# Rezoning Transportation Analysis

Petition Number: 2020-017

General Location Identifier: Tax ID 11101102

Date	Description
03-18-20	First Review
04-20-20	Second Review

RZ-1

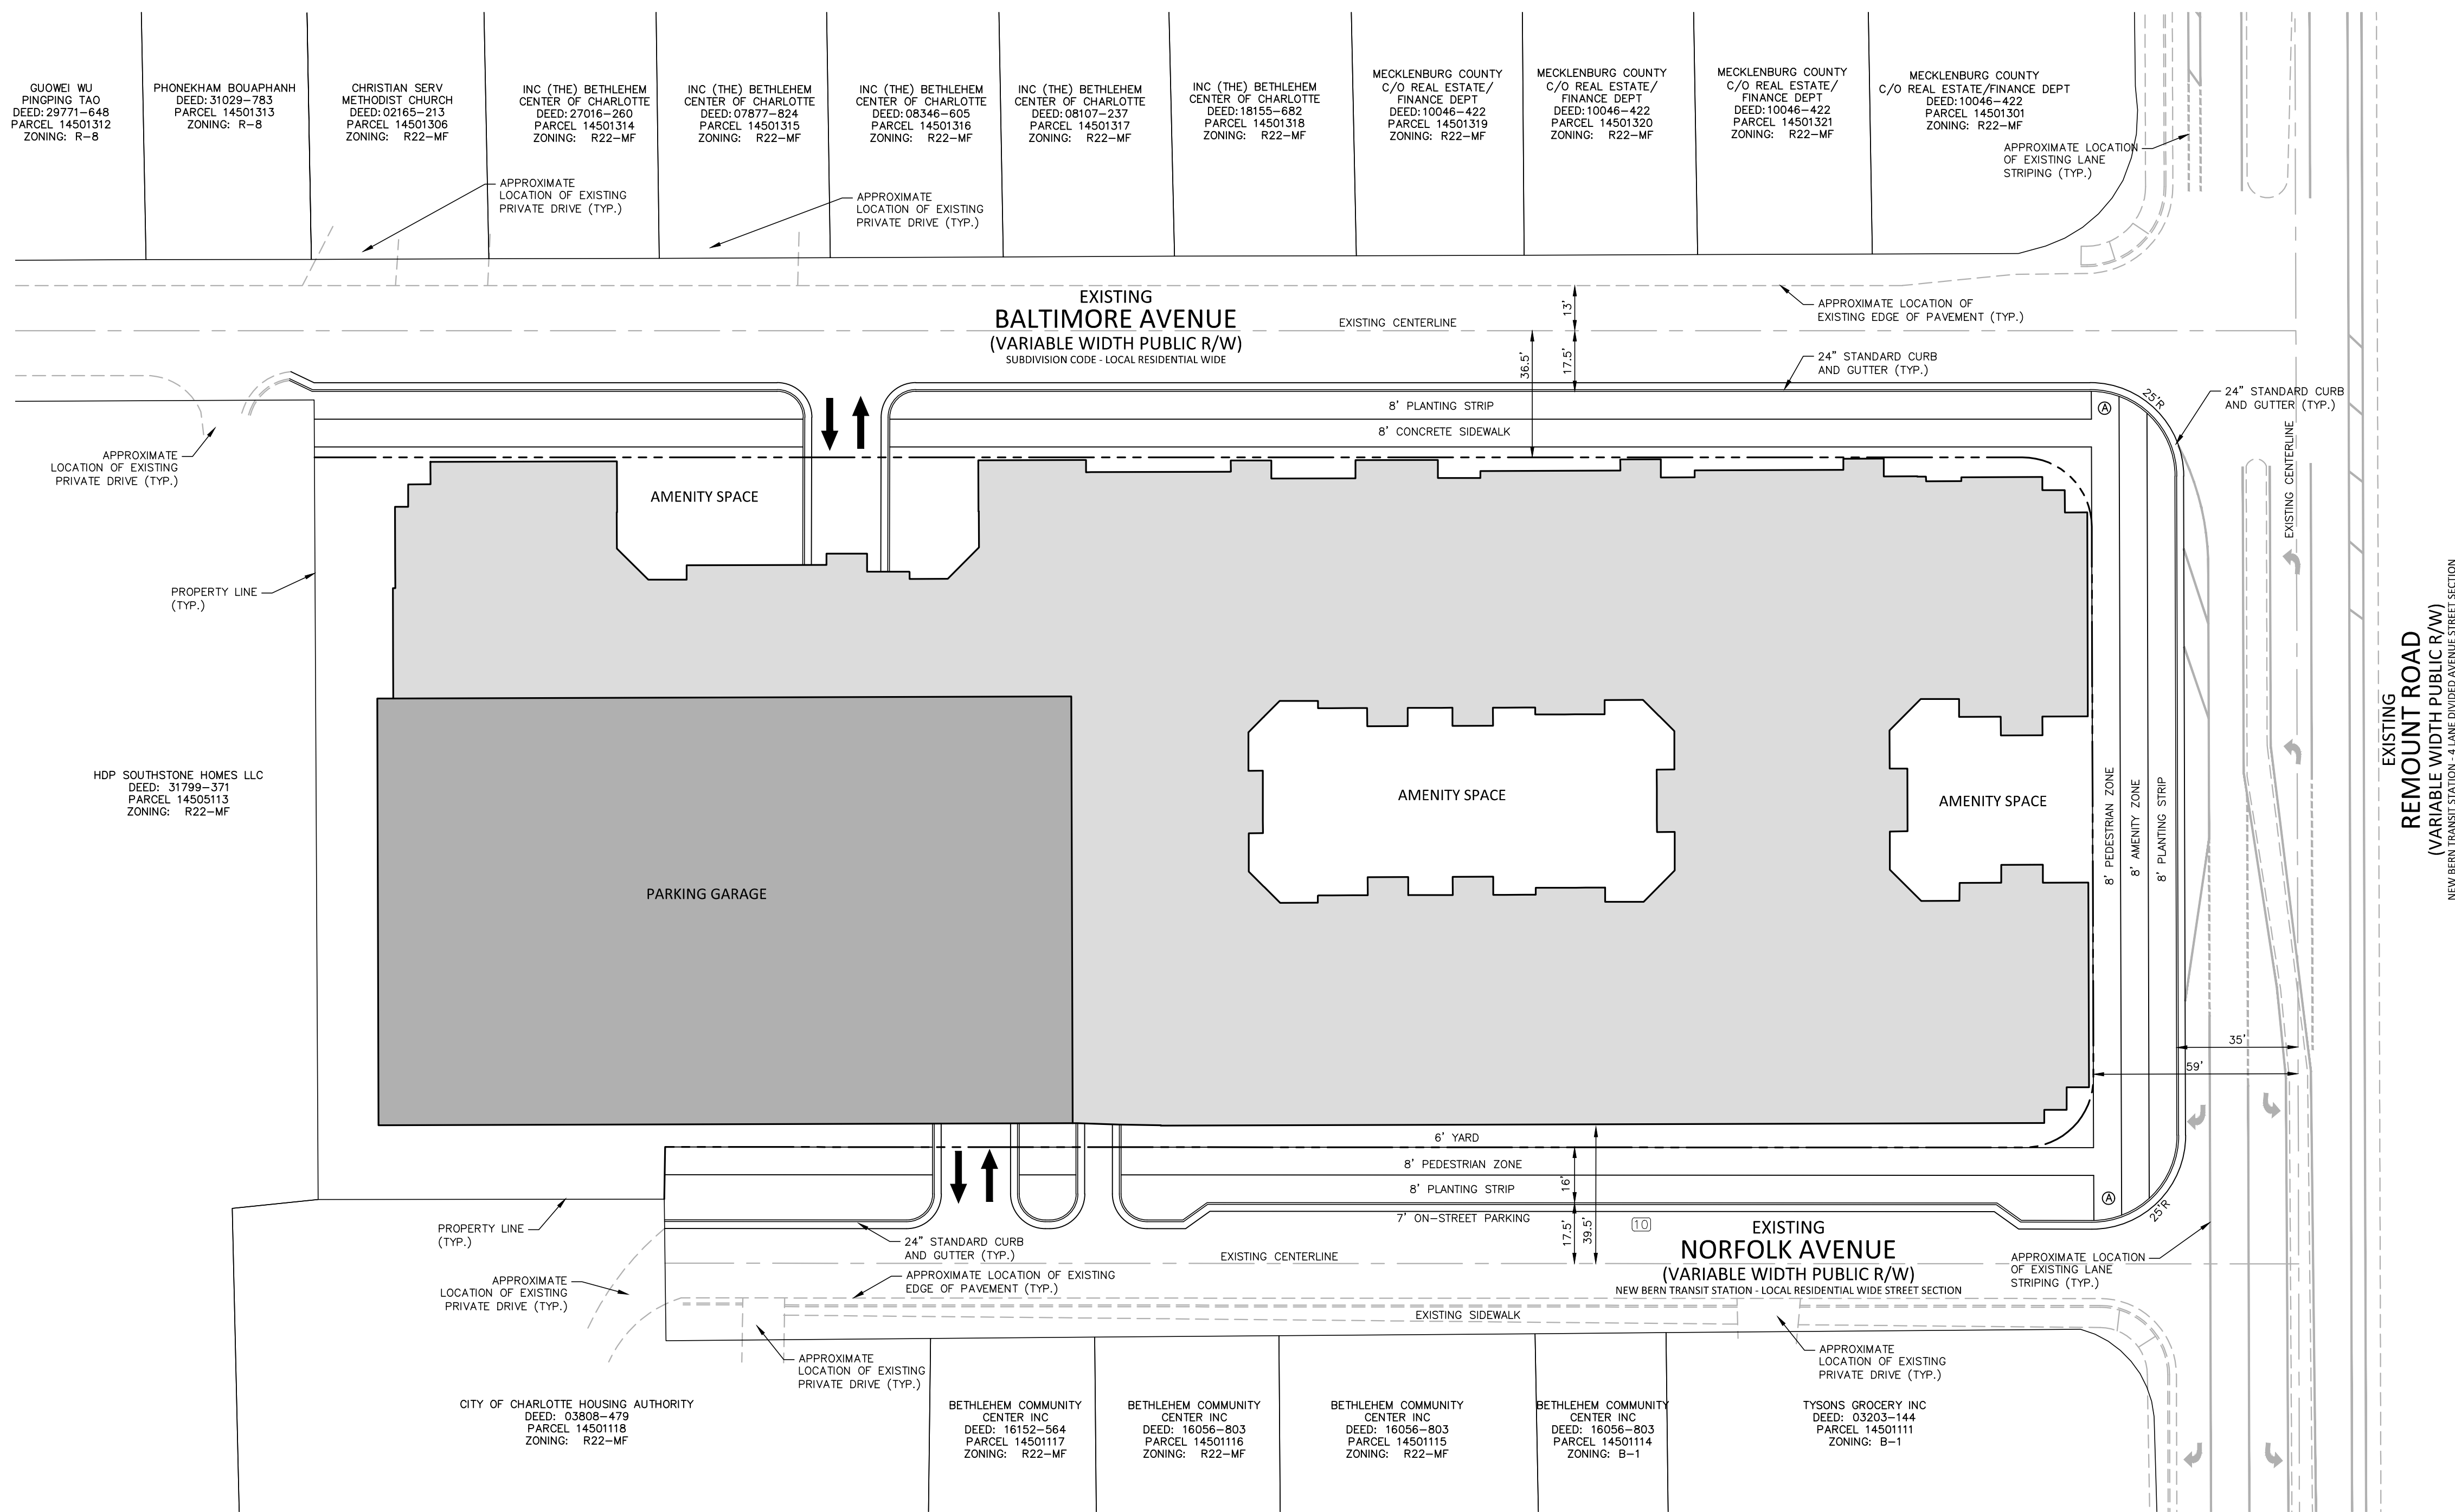
4. ~~Resolved~~ We request the petitioner to revise the site plan and conditional note(s) to construct a pedestrian refuge island across Remount Road, in reference to the Vision Zero Action Plan and enhanced intersection crossing included within the New Bern Area Plan. CDOT has notified Mecklenburg County of the possibility of the petitioner possibly attaining public utility and construction easements to improve the streetscape at this intersection. Please contact Jacqueline McNeil at ([Jacqueline.McNeil@mecklenburgcountync.gov](mailto:Jacqueline.McNeil@mecklenburgcountync.gov)) or (980-314-2511) and Bert Lynn at ([Bert.Lynn@mecklenburgcountync.gov](mailto:Bert.Lynn@mecklenburgcountync.gov)) or (704-589-7491). The pedestrian refuge may be unsignalized, but should still include MUTCD pedestrian crossing signage with a marked crosswalk. Please provide CDOT with an exhibit to review.

5. ~~Resolved~~ The petitioner is required to revise the site plan and conditional note(s) to widen the proposed access on Baltimore Avenue to a CLDSM standard for two-way traffic.

8. **Resolved** The petitioner should revise the site plan and conditional note (Section IV. Transportations, 3) to add specify dedication and fee simple conveyance of **all** rights of way to the City before the site's first building certificate of occupancy is issued. CDOT requests right of way set at 2' behind back of sidewalk where feasible.
9. **Resolved** The petitioner should revise the site plan and conditional note(s) to remove the proposed access on Norfolk Avenue, as shown below.

10. **Resolved** The petitioner should revise the site plan and conditional note(s) to clarify if the Norfolk Avenue on-street parking will be used to count toward Zoning Ordinance parking requirements. If so, one accessible on-street parking space will be required, affecting the proposed streetscape along Norfolk Avenue.

- a. **Technical Clarification** The petitioner should revise the site plan to show the edge line measured parallel to the edge of pavement and curb line.

11. **Resolved** In reference to the Charlotte BIKES adopted plan and CDOT Streets Map, CDOT requests the petitioner to revise the site plan and conditional note(s) to restripe the area below to replace the existing eastbound right turn lane in favor of extending the buffered bike lane to the intersection of Tryon Street. This request is also supported to establish a constant bike facility connection to the Rail Trail directly into South End.

12. **Outstanding** The petitioner should revise the site plan and conditional note(s) to clarify the trash container locations and how handling will be performed.
13. **Rescinded, bicycle parking is required per Section 12.202 and 12.202A of the Zoning Ordinance.** The petitioner should revise the site plan and conditional note(s) to include the location of Zoning Ordinance required bicycle parking.
14. **Resolved** ~~Sample format for comment that is resolved~~
